CONSTRUCTION PLANS
FOR
CREEKSIDE AT LORSON RANCH FILING NO. 2
STREET AND STORM SEWER CONSTRUCTION PLANS

CREEKSIDE AT LORSON RANCH FIL. 2 STORM SEWER CONSTRUCTION PLANS

TYPICAL SECTION 50' R.O.W.
RESIDENTIAL URBAN LOCAL
NOT TO SCALE

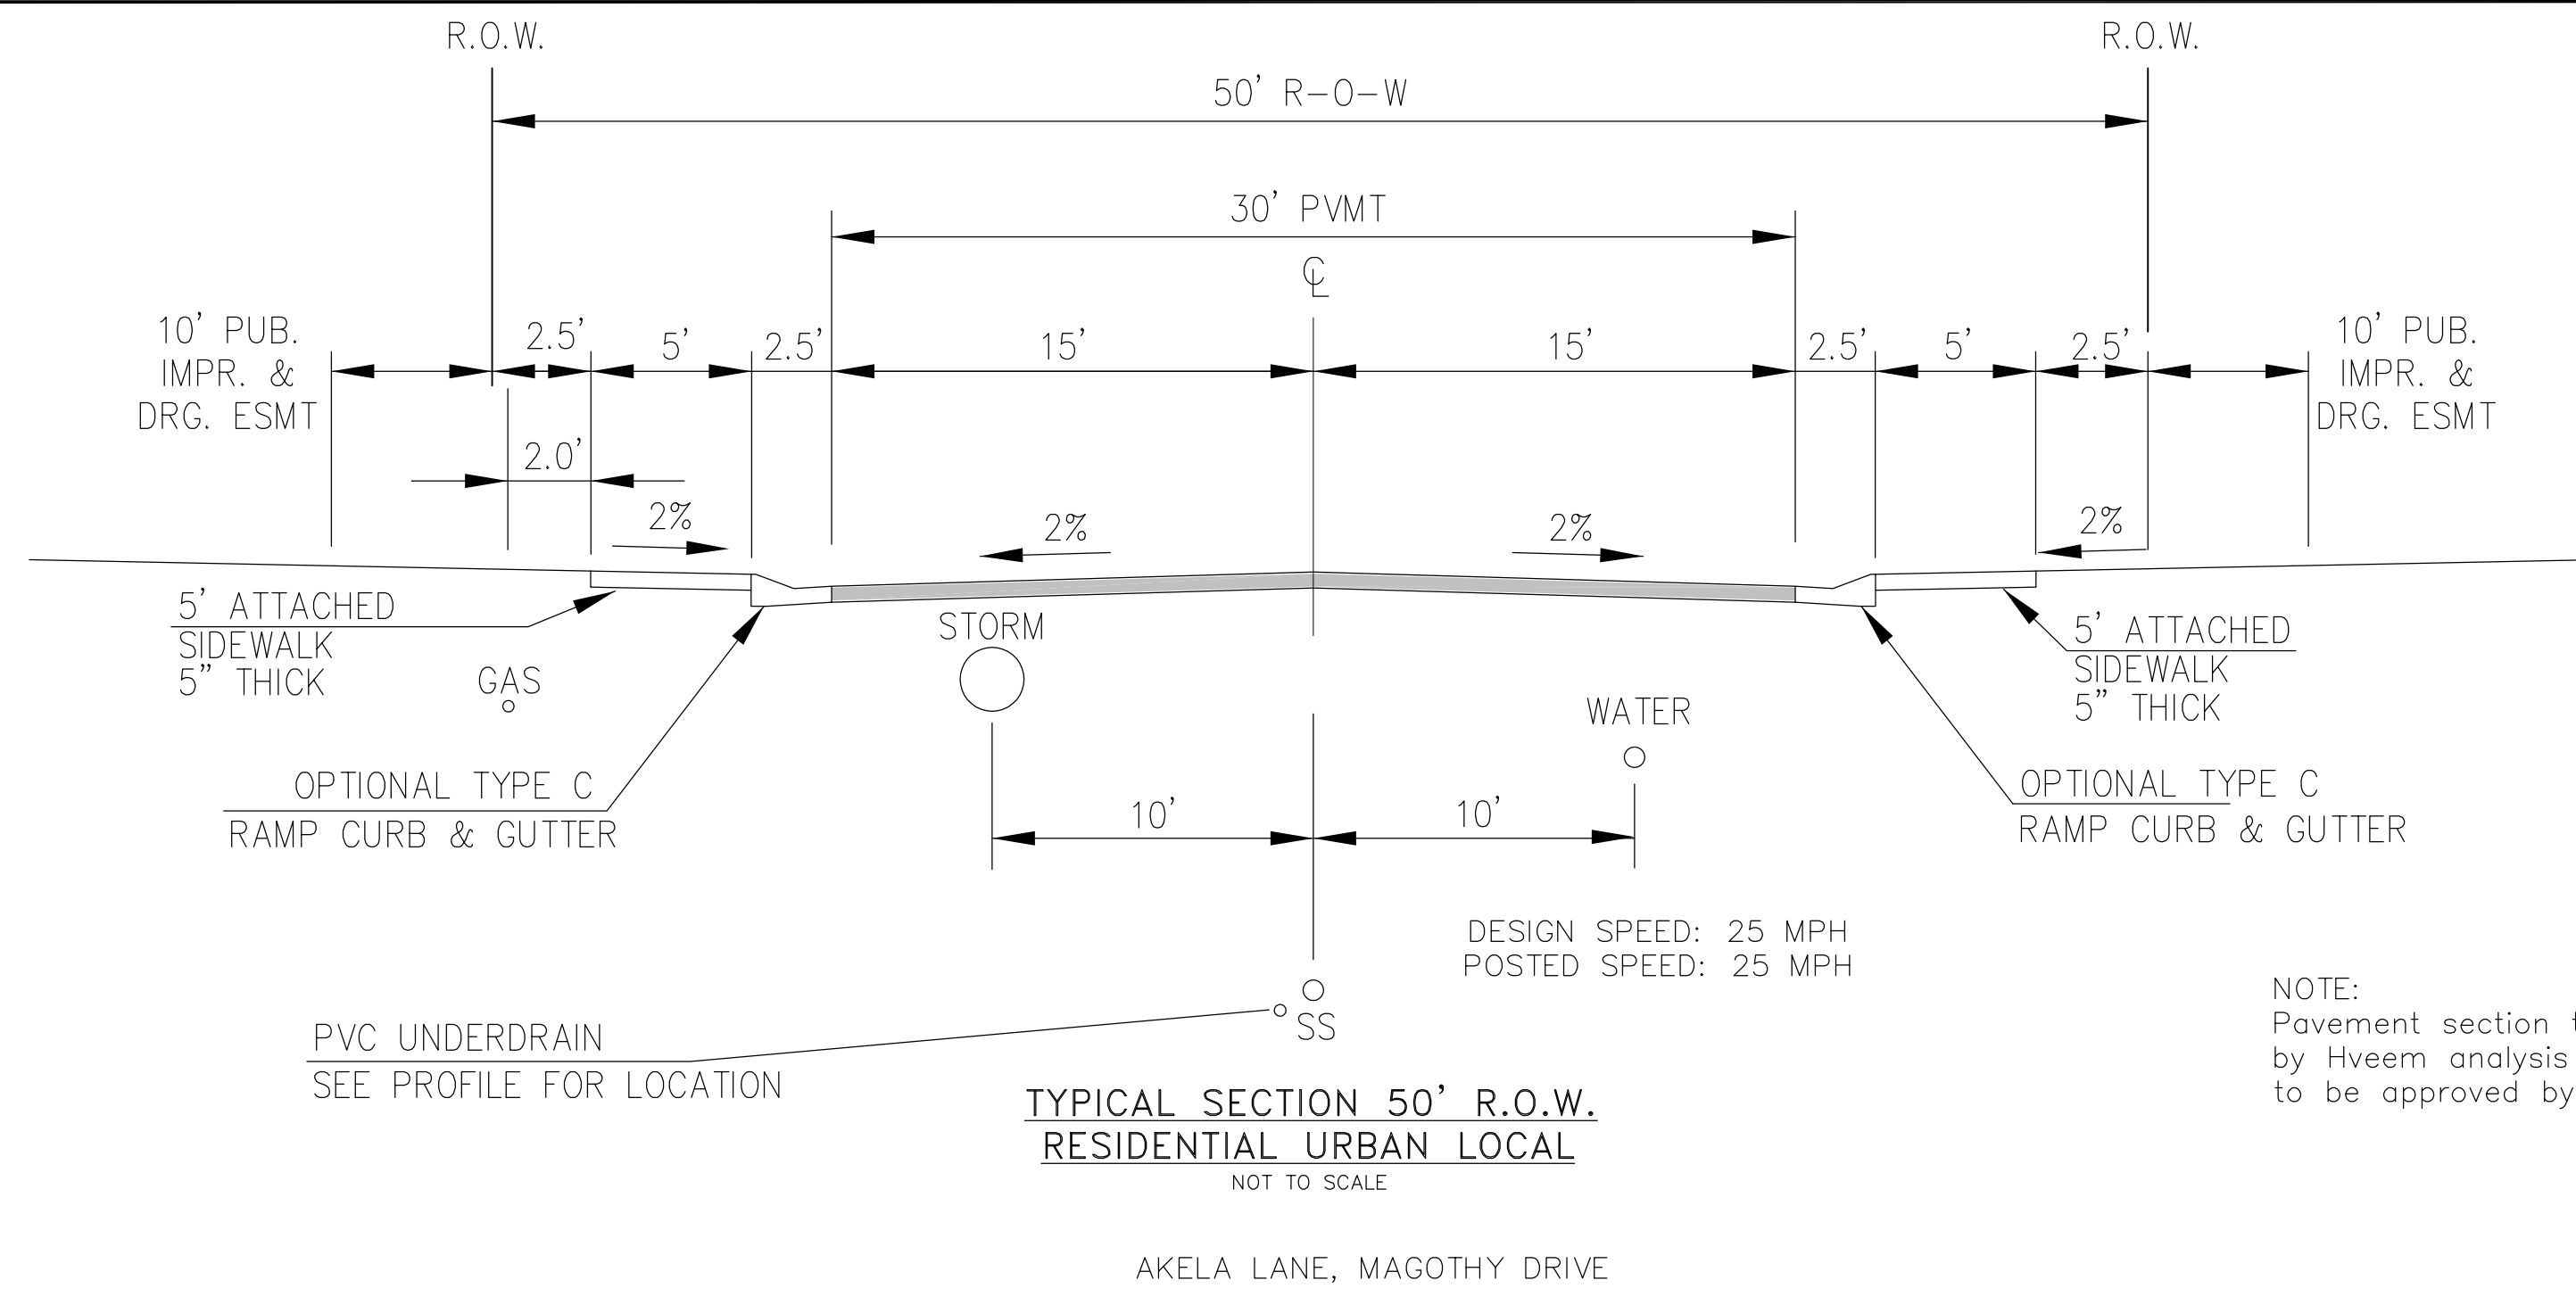
Per typical section on GEC plan set, public improvement easement is 10'. Update sections between plan sets to be consistent.
